CITY OF ALBUQUERQUE

Pete Daskalos, Krania LLC, Kirstie@daskalosdi.com
Site: Starbucks/T-Mobile at 98th and Central

Re: Drainage Ordinance (14-5-2-1) Violations for Erosion and Sediment Control

Erosion Sediment Control Plan

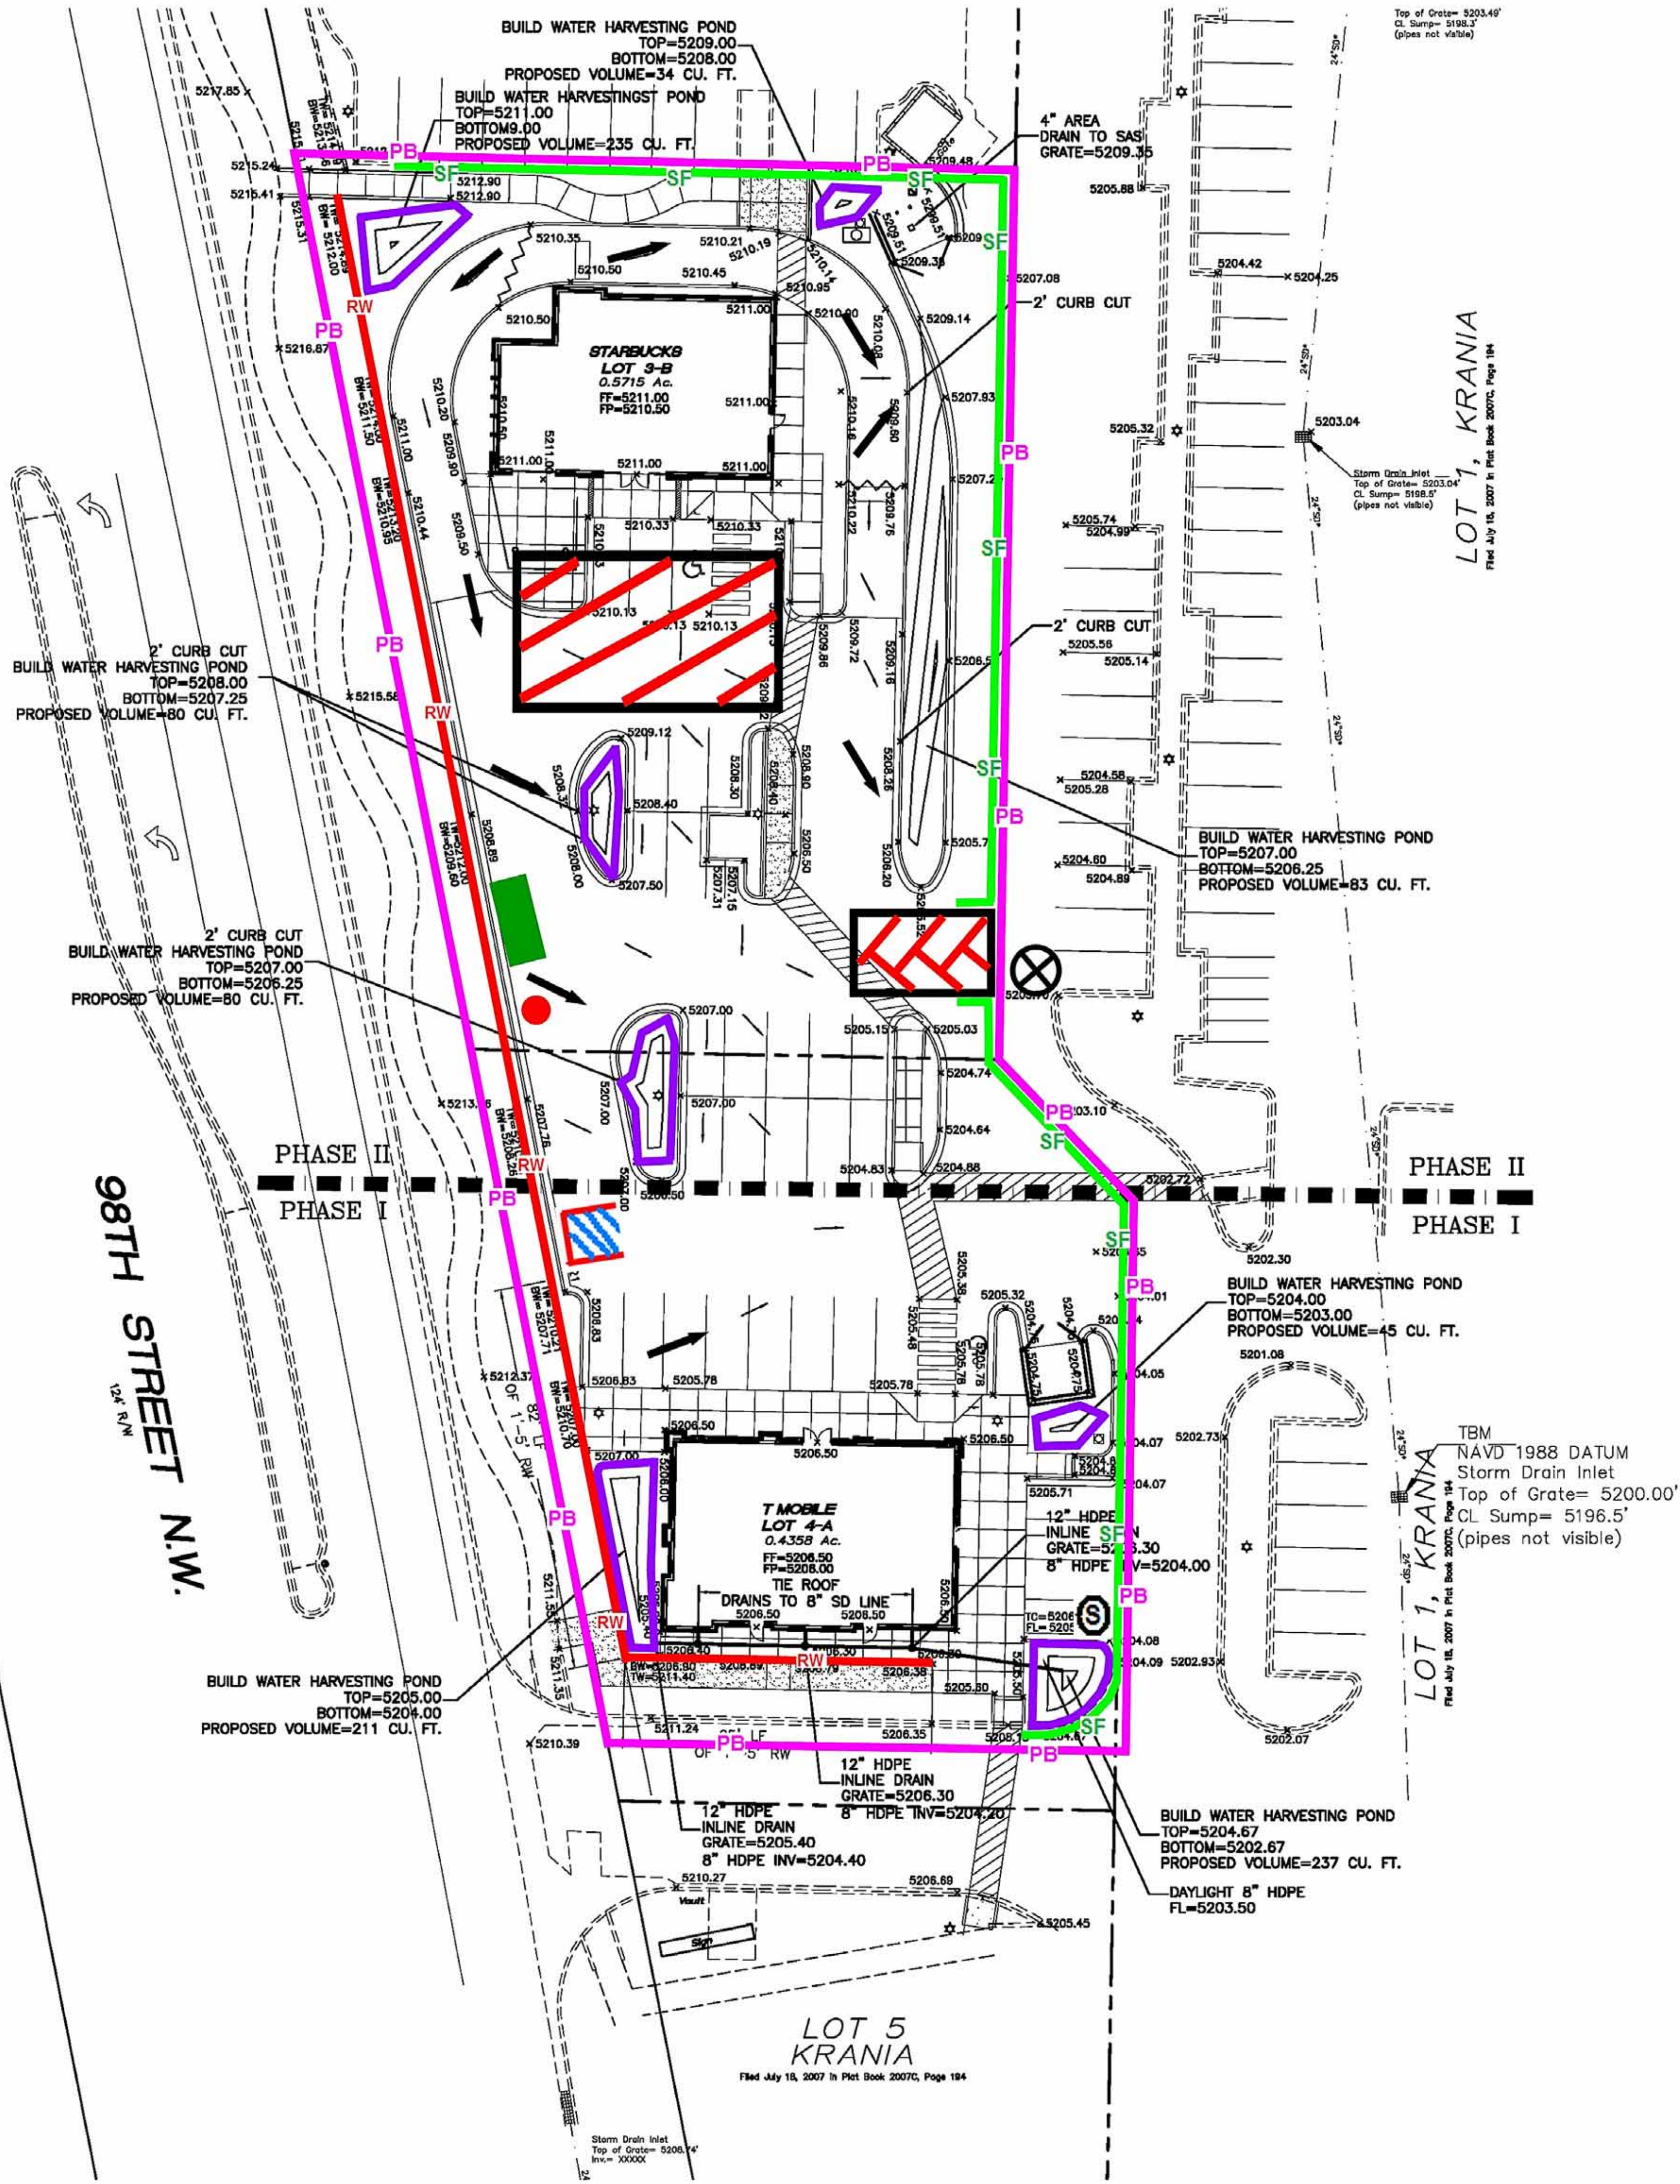
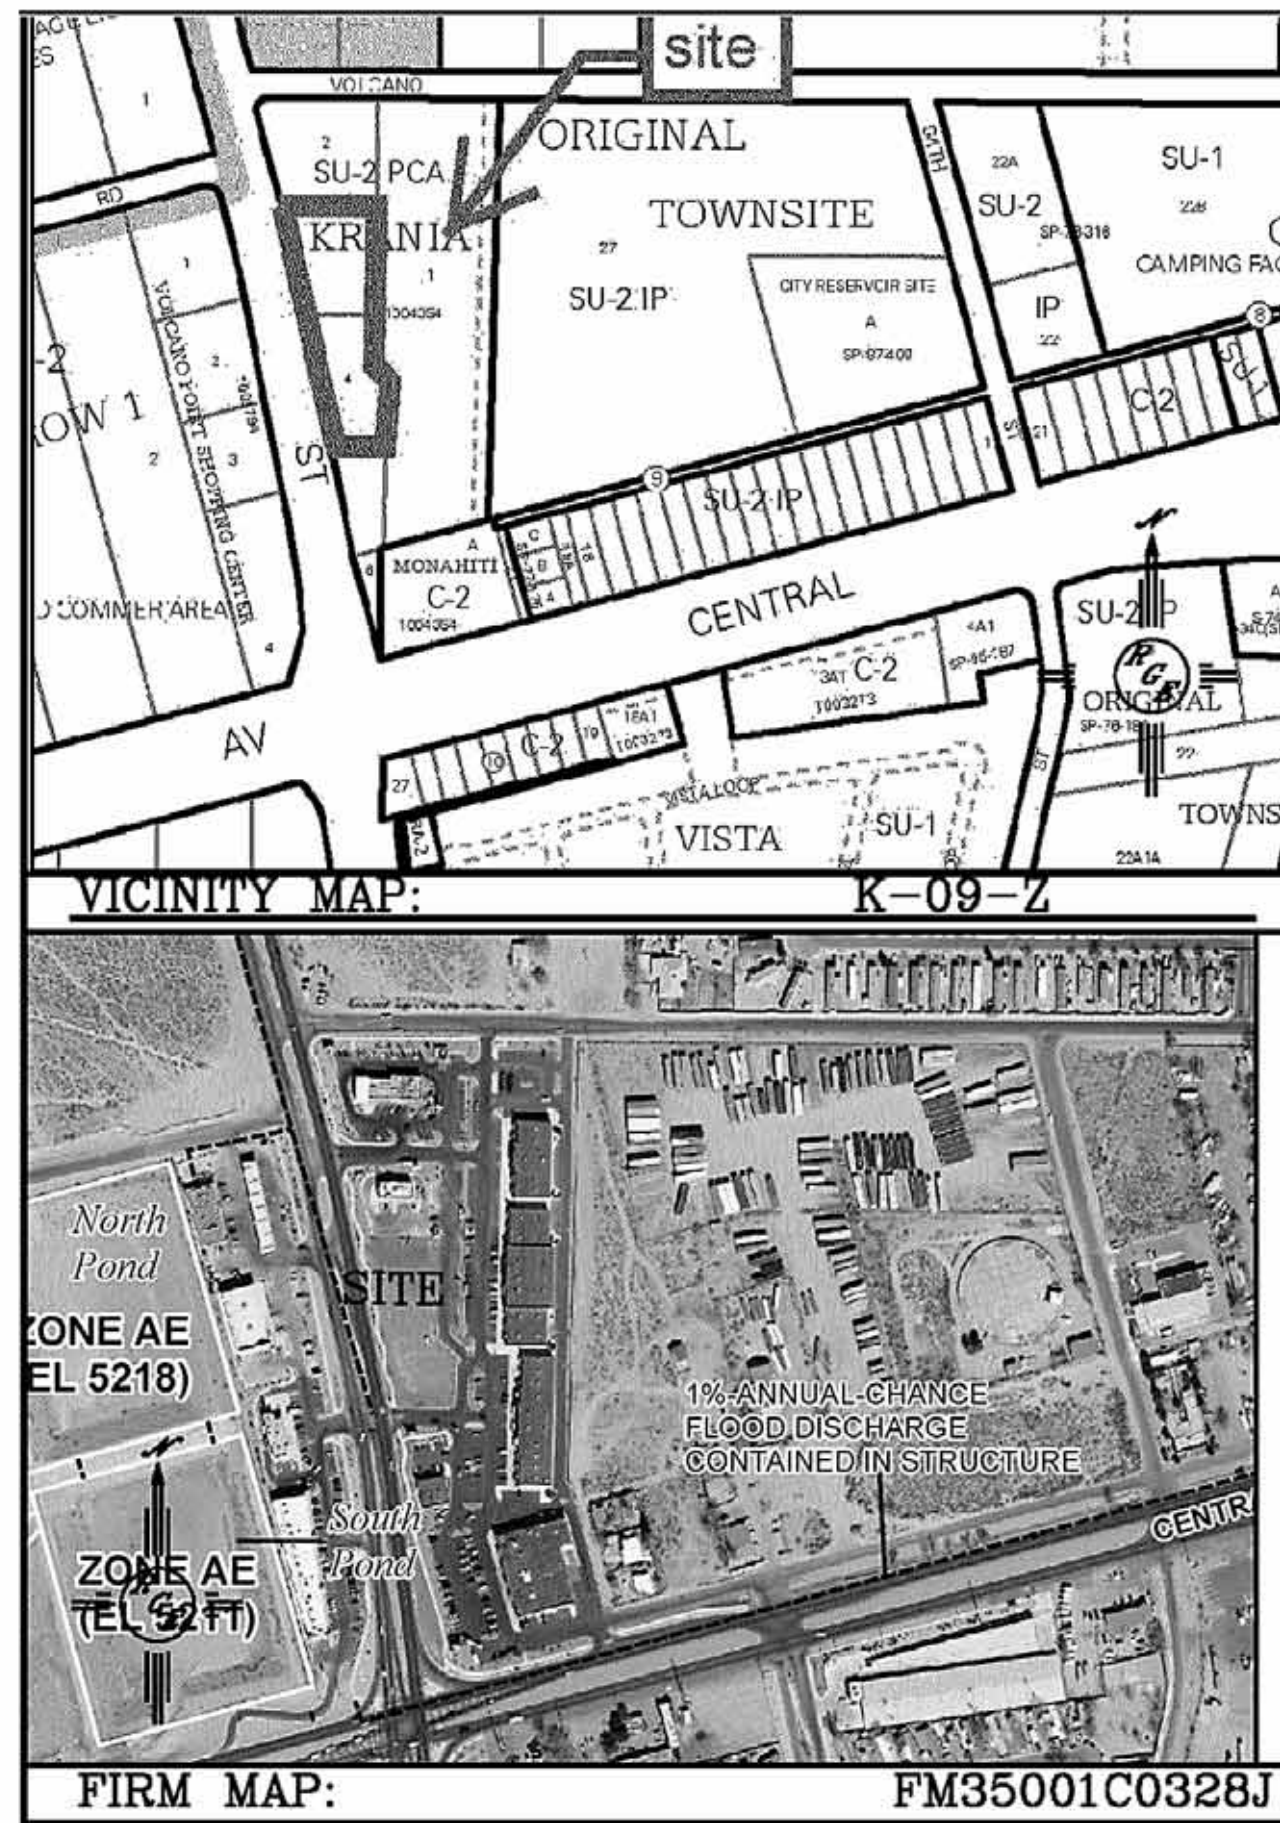
1. Inlet protection was not installed.
2. Sediment was present in parking lot.

Inlet in parking lot east of site that is to have inlet protection (flush- cocoa mat or similar).

Sediment in area that drains to unprotected inlet.

Sediment and oil/hydraulic fluid in area that drains to unprotected inlet.

1. Install inlet protection (flush- cocoa mat or similar) on inlet east of site in parking lot, if earth disturbing activities are still ongoing.
2. Remove sediment from parking lot.
